From: Geoff Thorpe [REDACTED]
Sent: 27 June 2019 10:59
To: Planning
Subject: Applications AB/48/19/PL and AB/49/19/L - for the attention of Mrs Gardner

A6001-03
1 : 100 @ A2
29.04.19

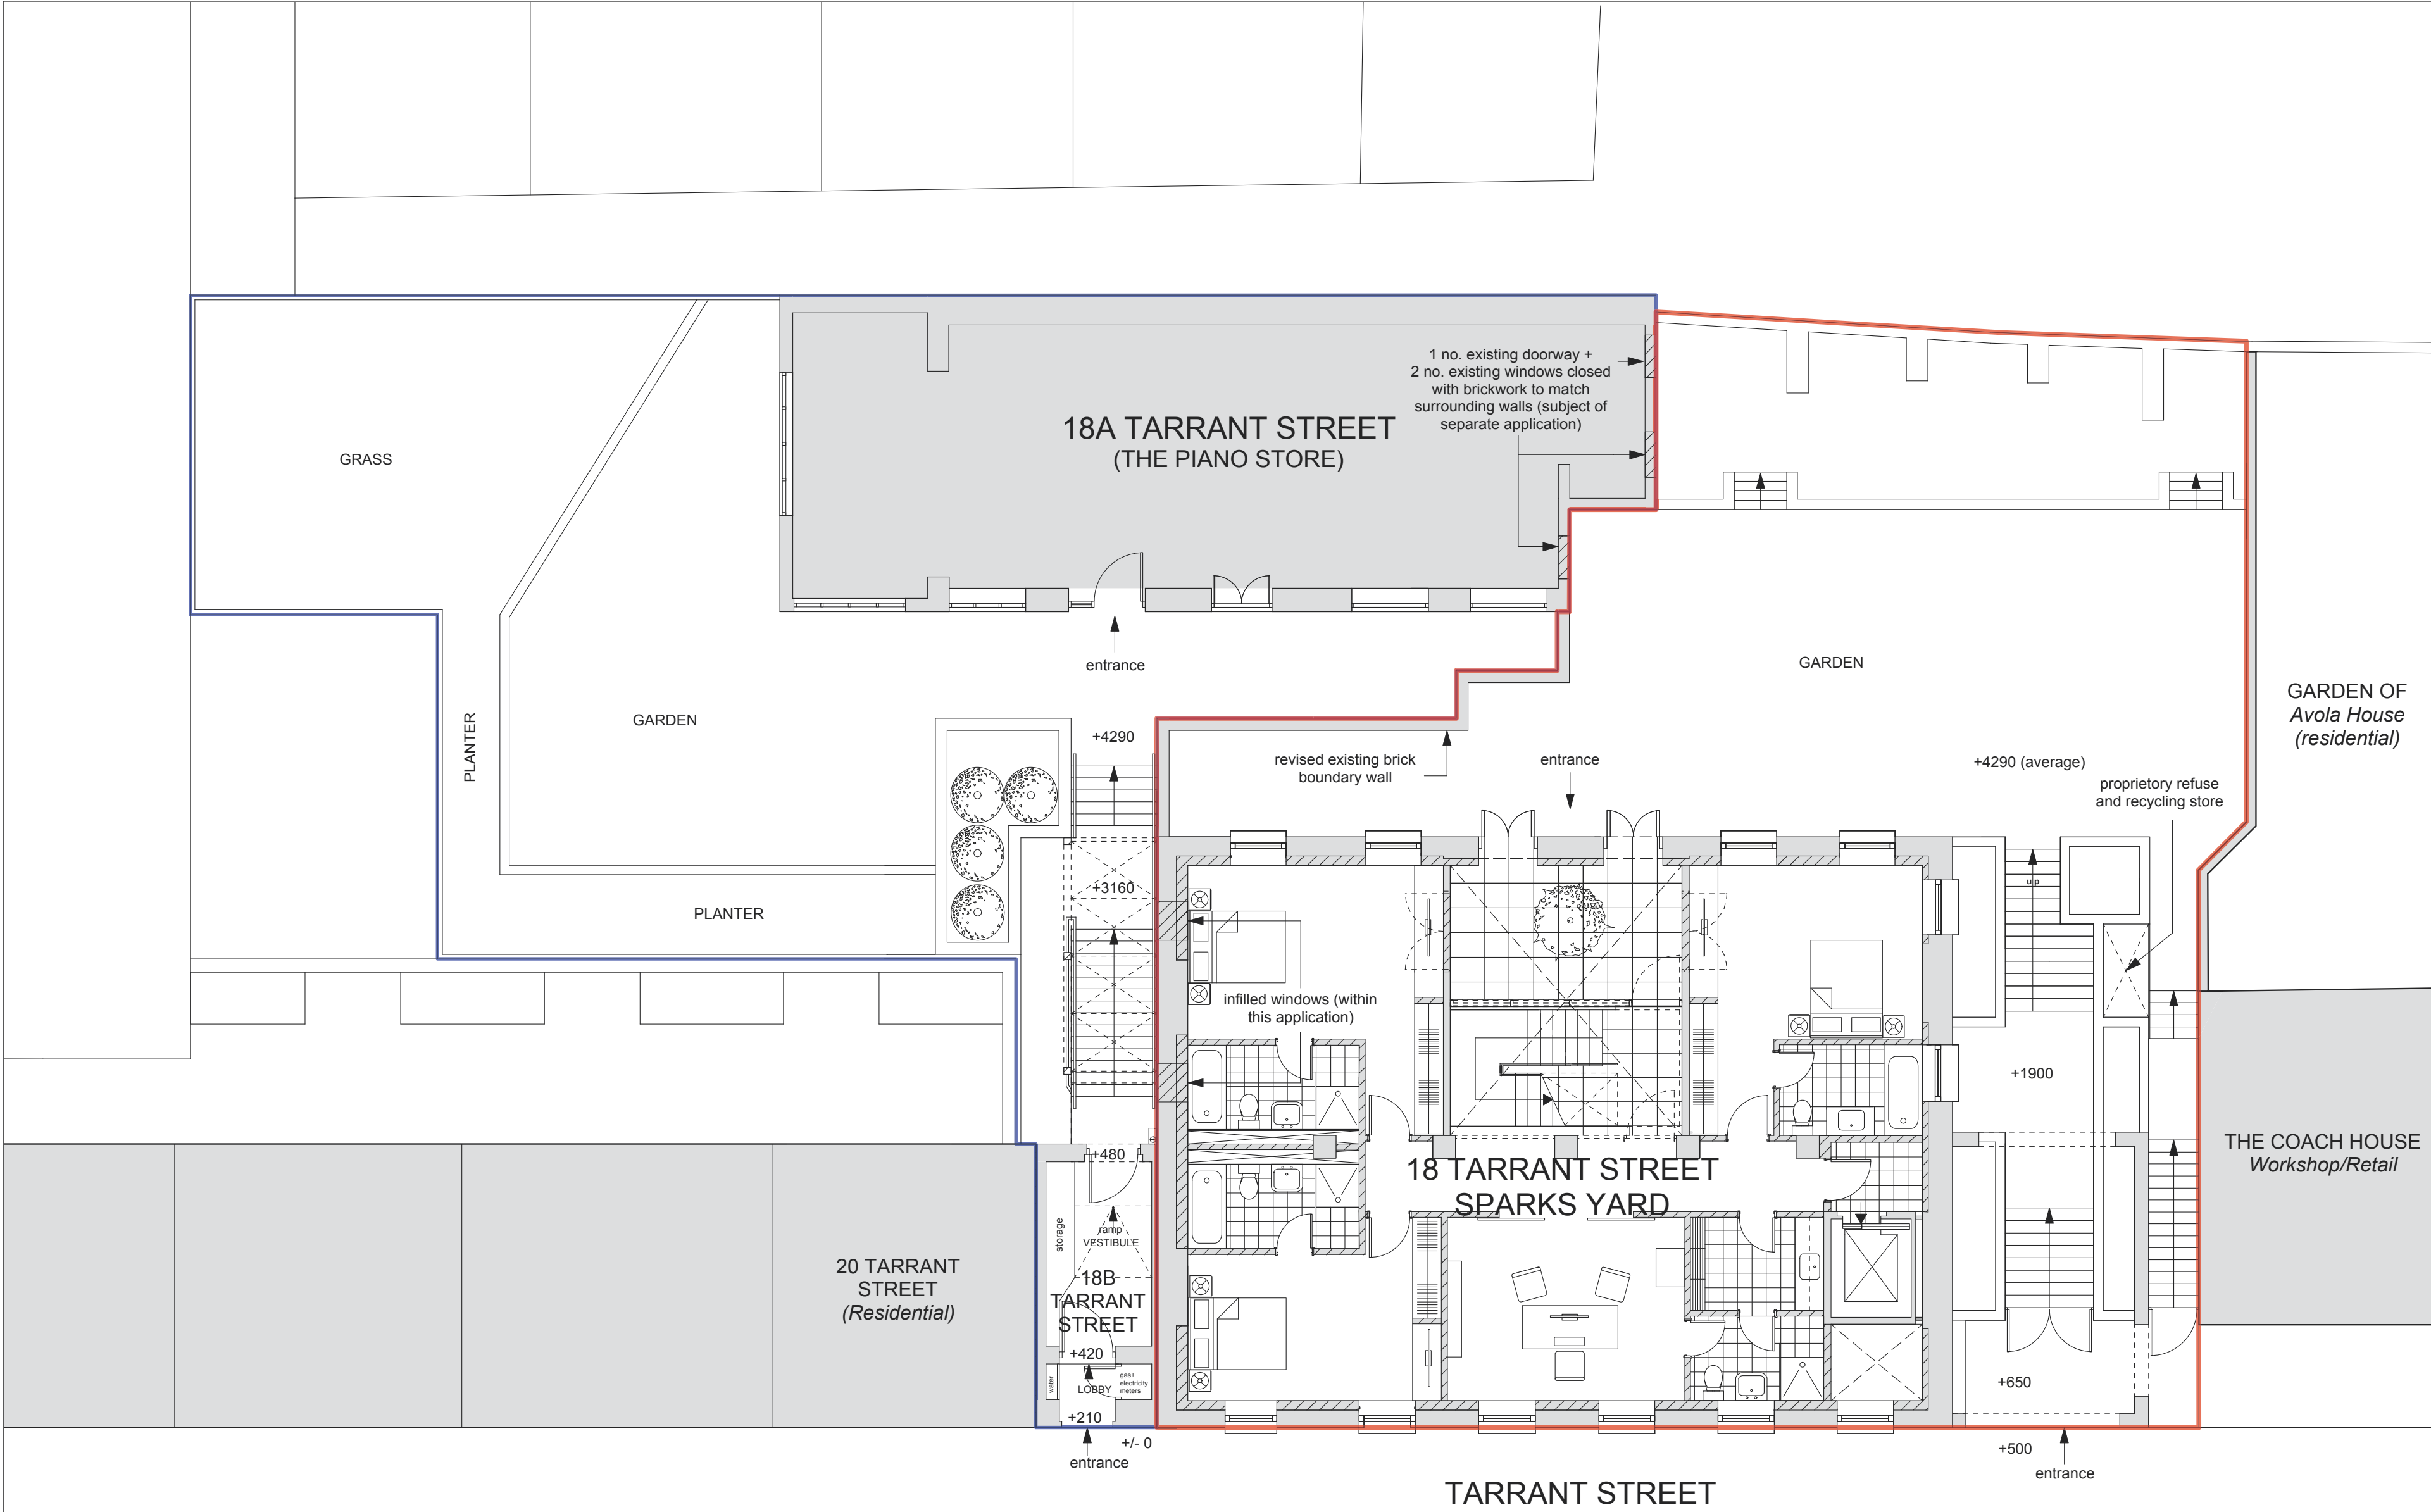
5. My apologies. Looking at the drawings as submitted, it is not at all clear exactly what the 'revised existing brickwork wall' noted in drawing A6001-03 actually is! Our other application in respect of the adjacent property [AB/50/19/PL] is much clearer, but for some unknown reason we did not include this information in the submitted drawings for these applications. We are currently revising drawing A6001-03 to include this information and intend submitting it to you as amended drawing no. A6001-03 revision A, later today.

A6001-08

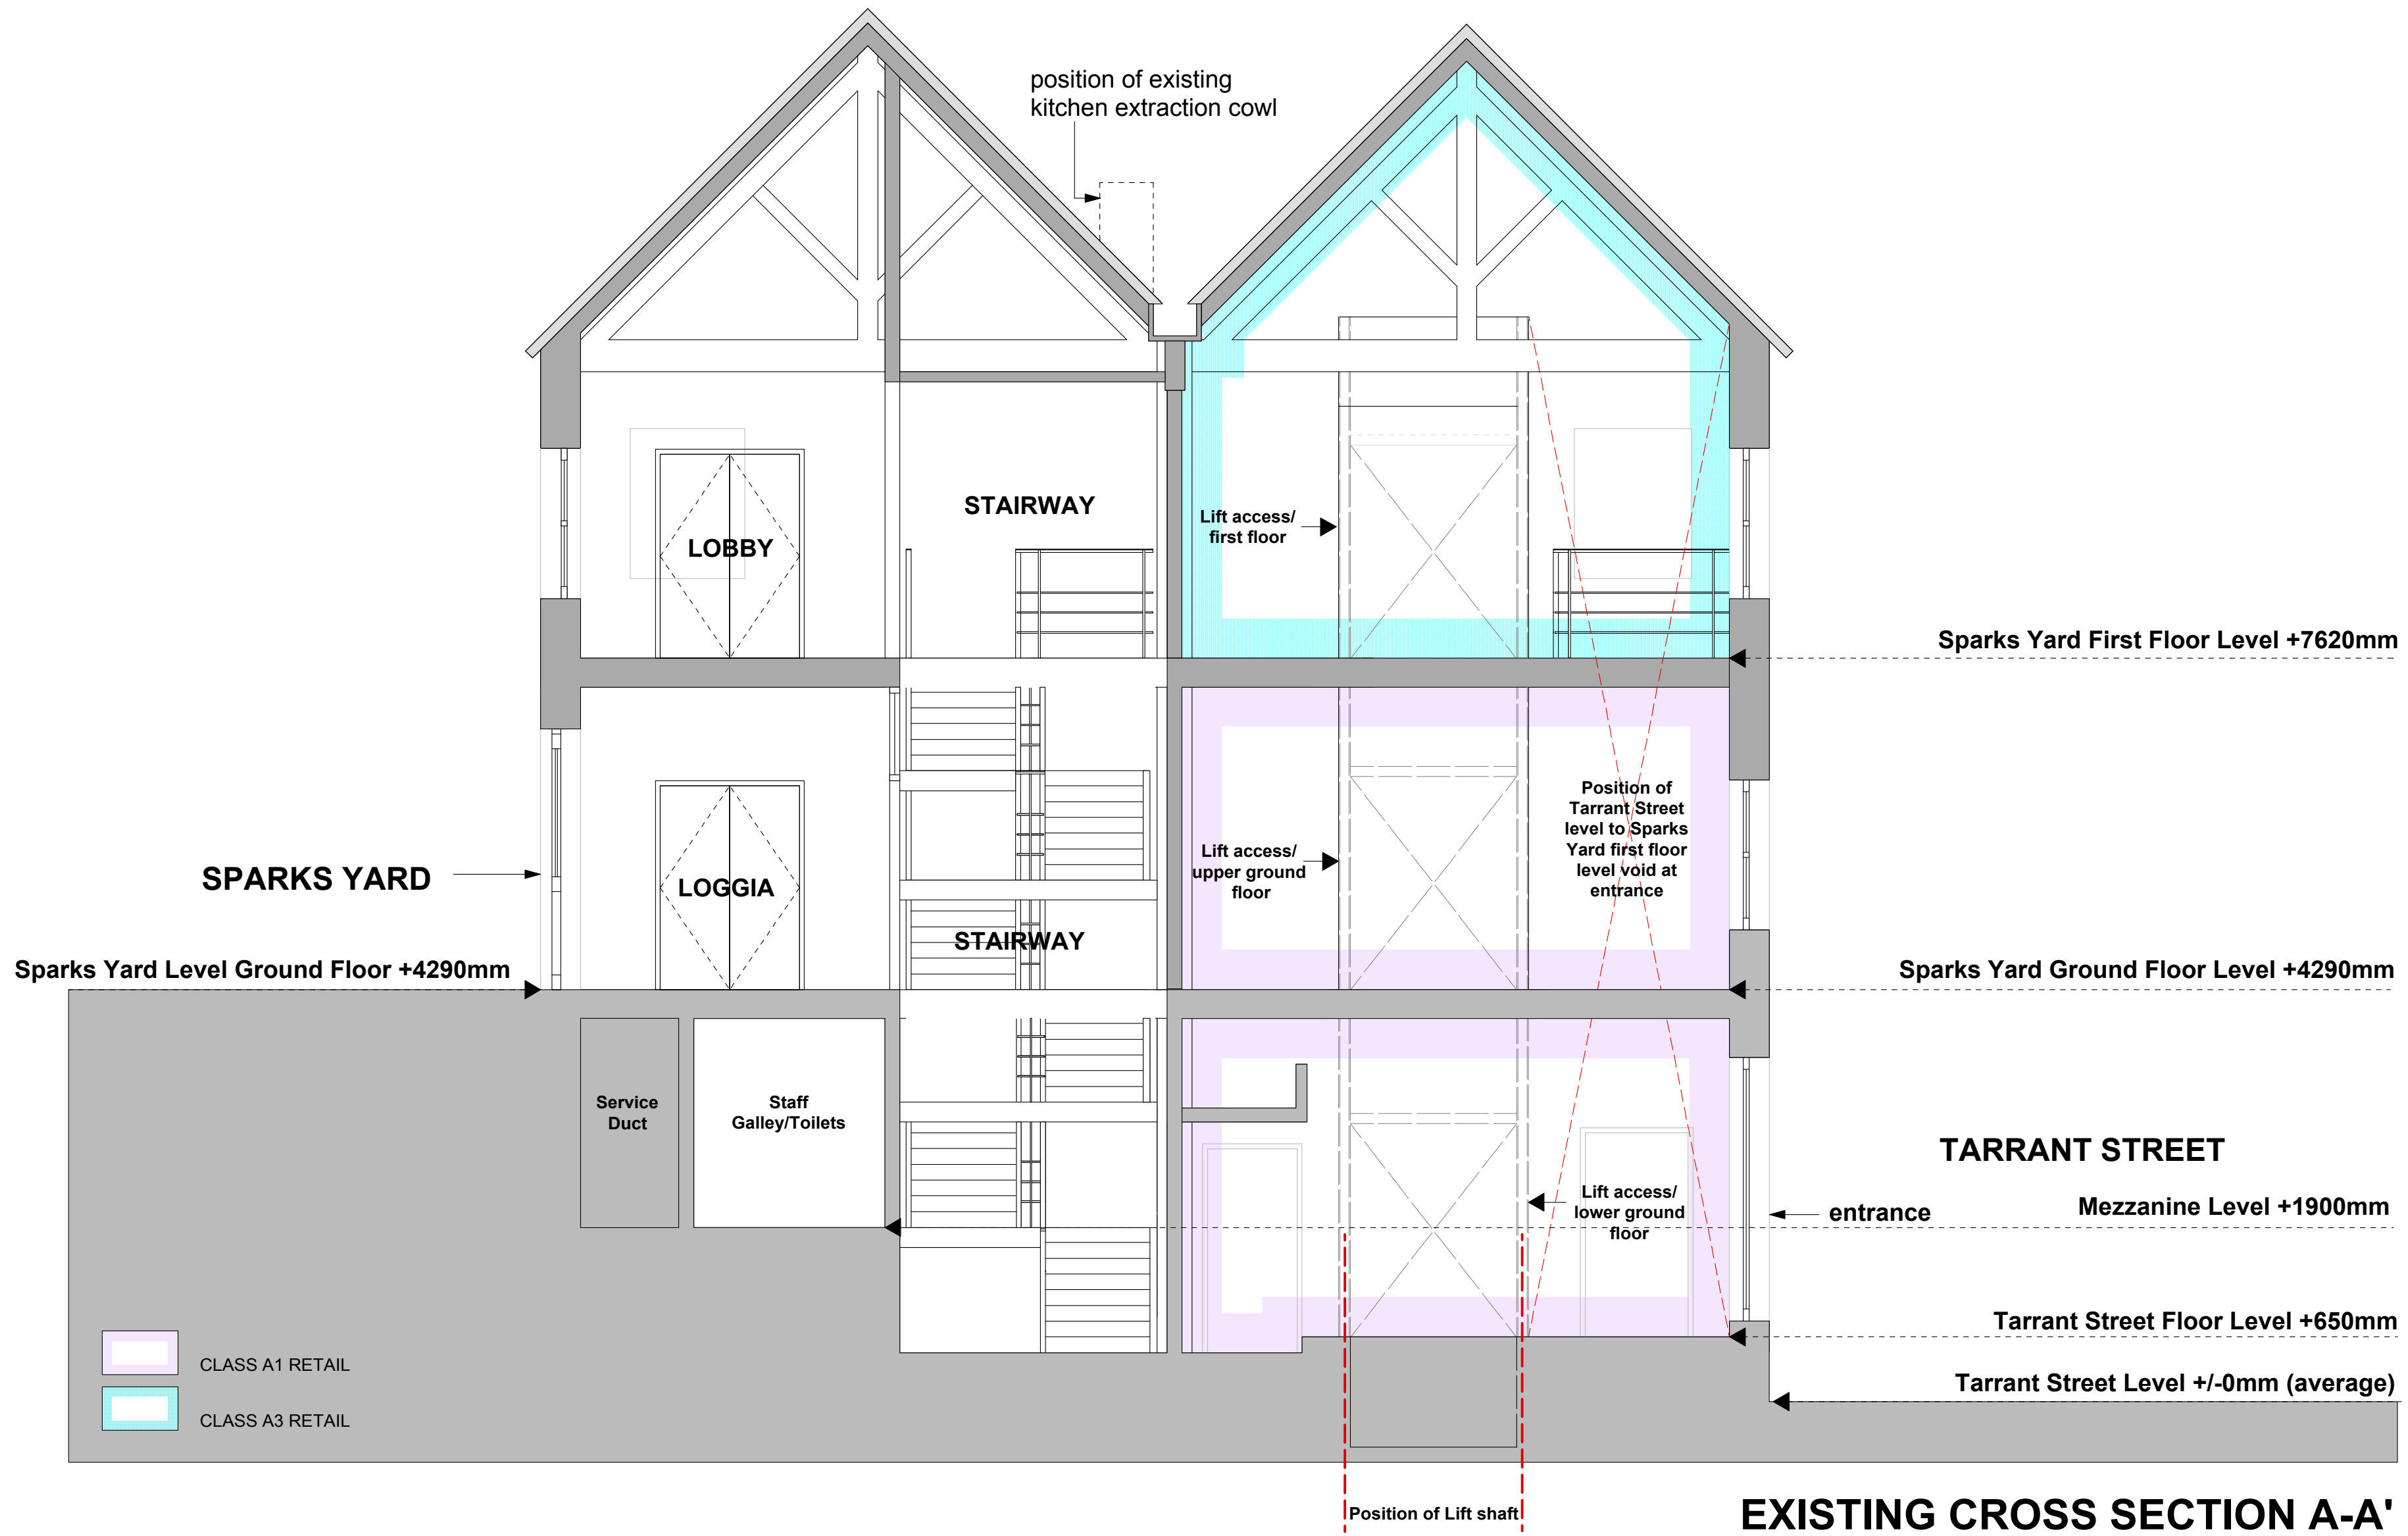
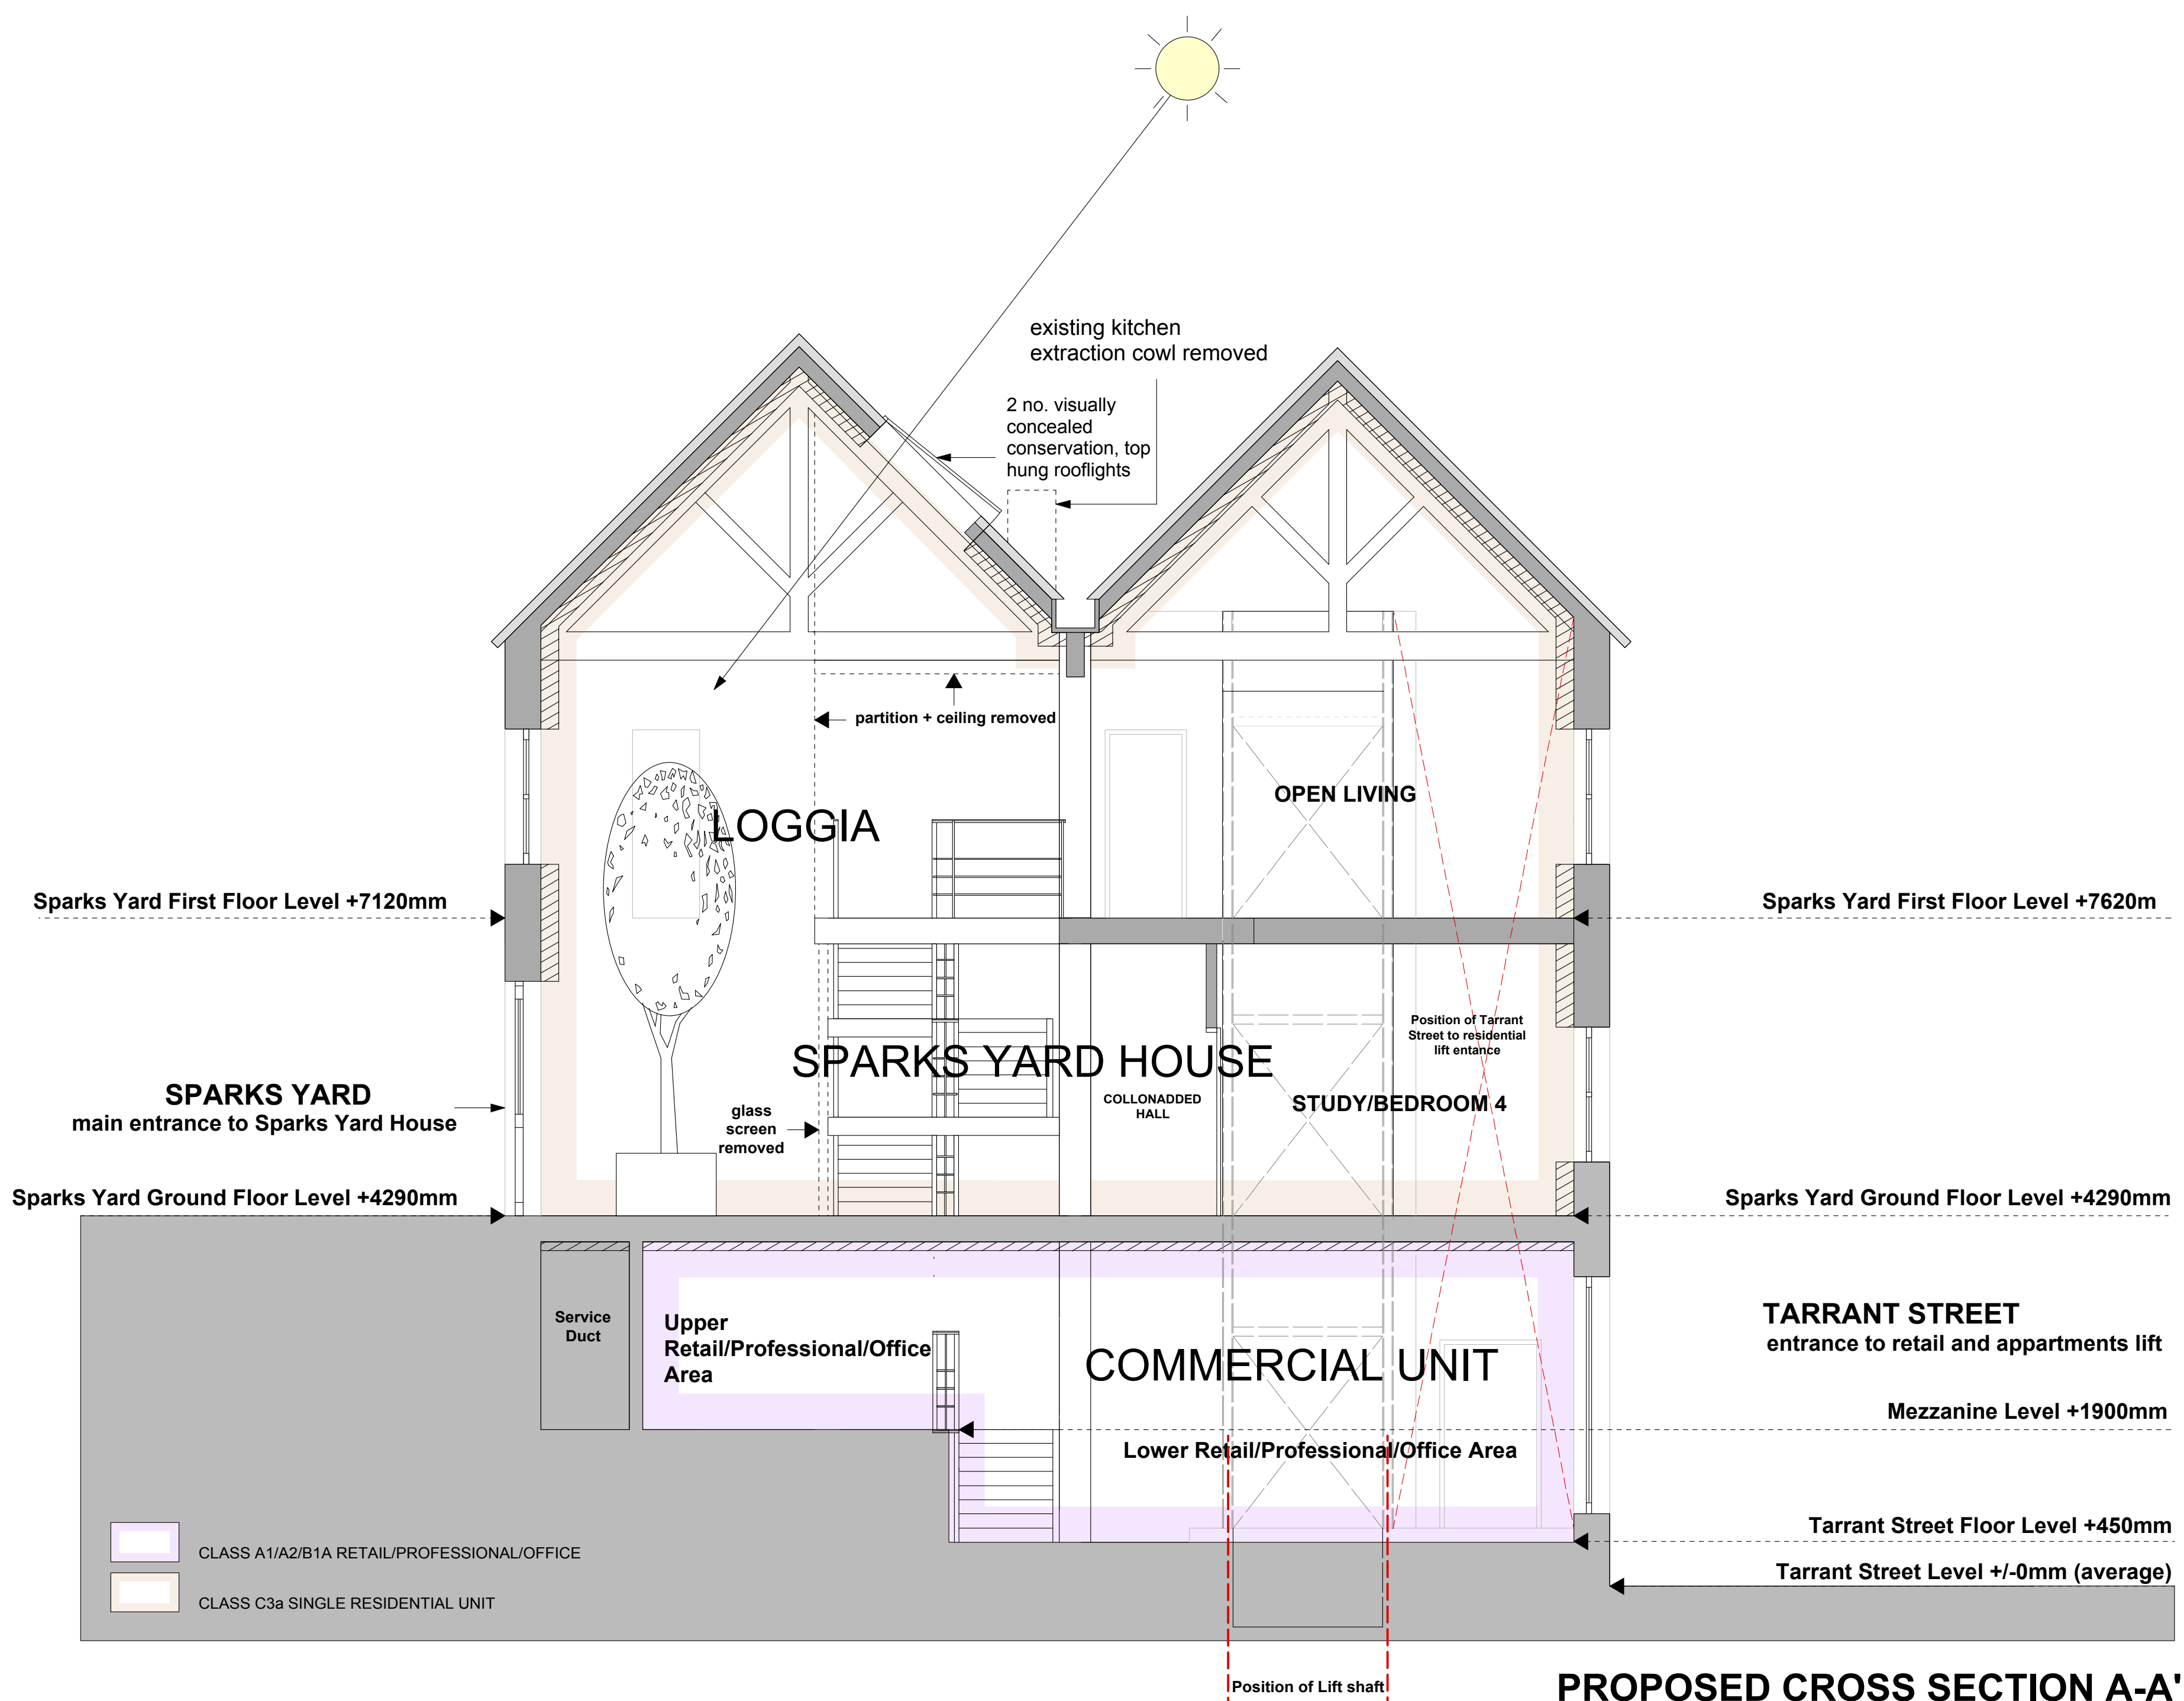
2. I am delighted to read the concerns relating to the lining of the external brick walls with insulation and plasterboard. We do not wish to do this and it was only included in the proposal in order to satisfy the inevitable thermal insulation requirements of building regulation approval. I confirm therefore that we wish to amend our applications in order to remove all proposed external wall linings to the upper two floors of the buildings and will seek an agreement to relaxation when the building regulation approval

application is made, citing its unacceptability for inclusion within this listed building. Would you like us to submit amended drawings to cover this or can this be covered by a potential condition?
